**From:** patrickprendergast@bucksplantcare.co.uk  
**Sent:** 15 October 2021 09:03  
**To:** James Kirkham  
**Cc:** Jonathan Emanuel  
**Subject:** RE: Planning notification for application reference: 21/02417/F

I have received an updated Arboricultural Addendum Note. It is available on the file. I also attach it for ease. Could you please let me know your comments?

I am commenting on the above application from an arboricultural aspect.

Figure 1. Extract of Tree Protection Plan showing location of dwelling house within the RPA of tree T1.

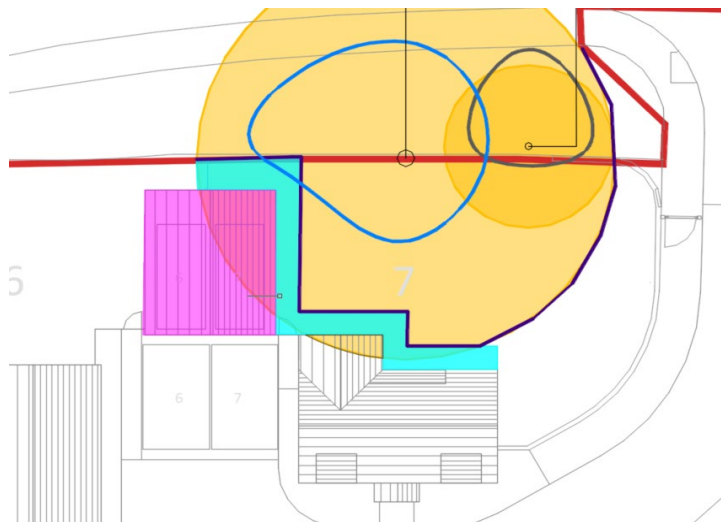
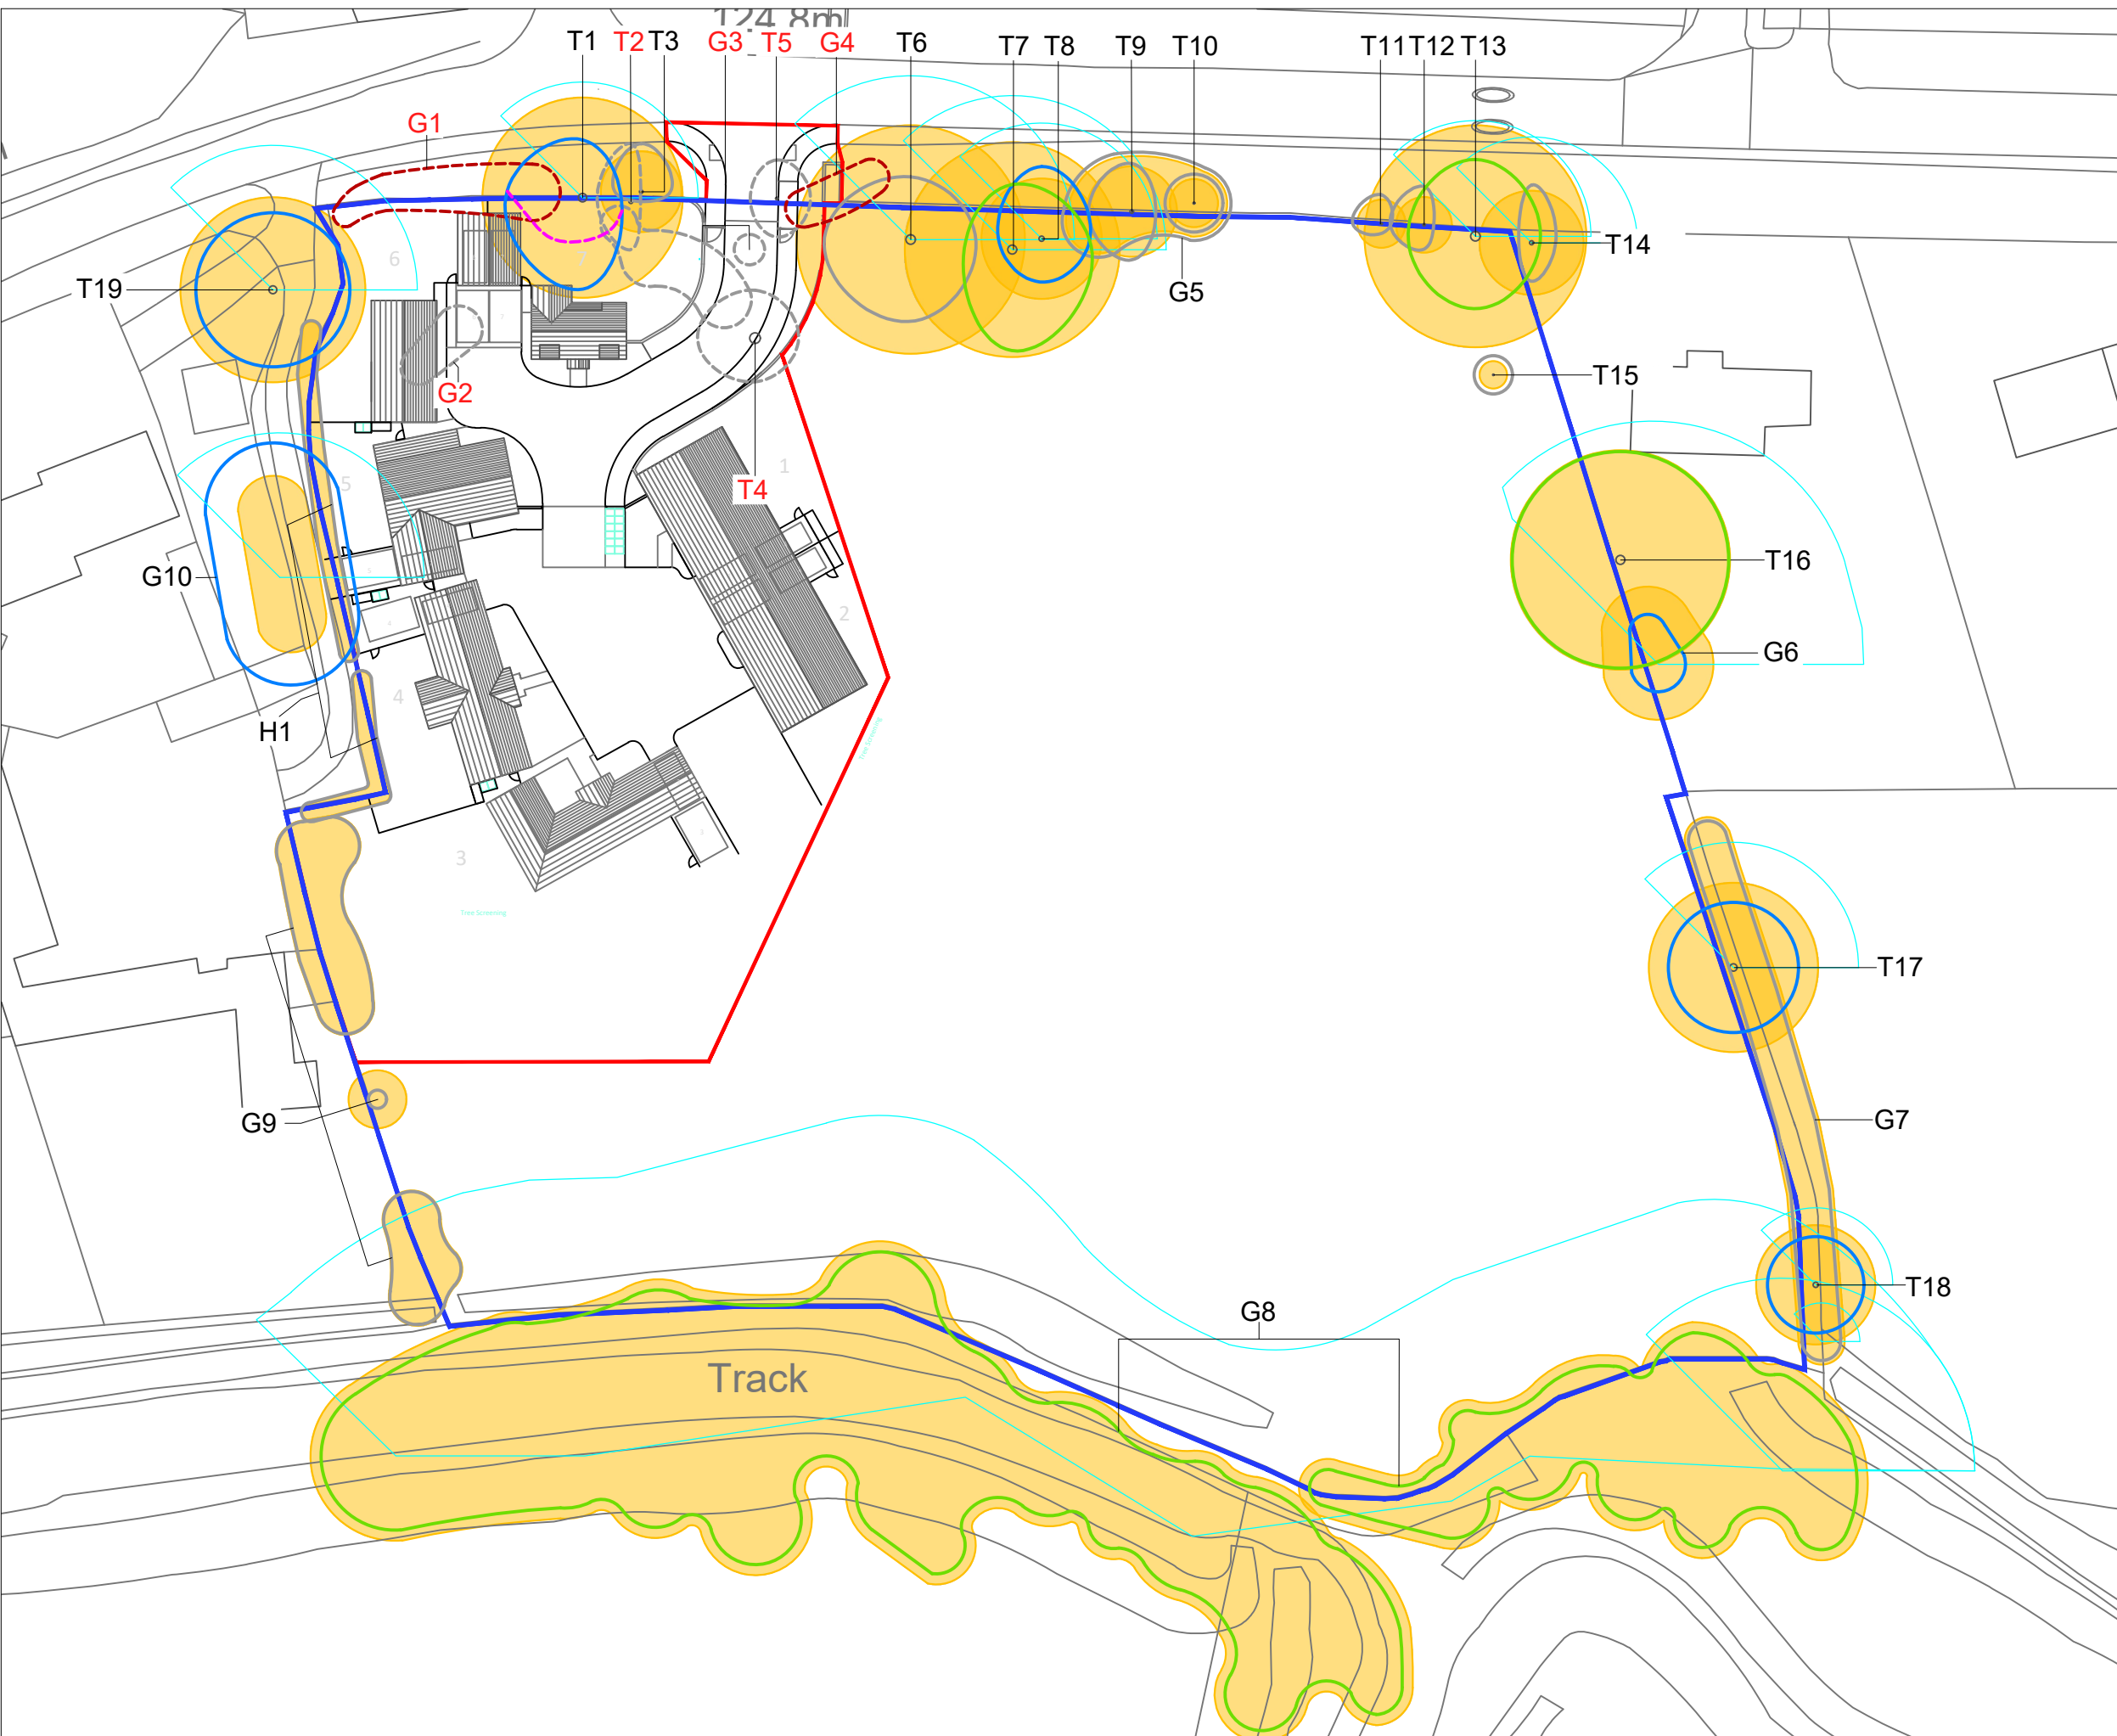
I am happy with that minor change.

1. An updated arboricultural report will be required in line with BS5837(2012) with impact assessment plan.

If approved then a condition if required for a detail Arboricultural Method Statement
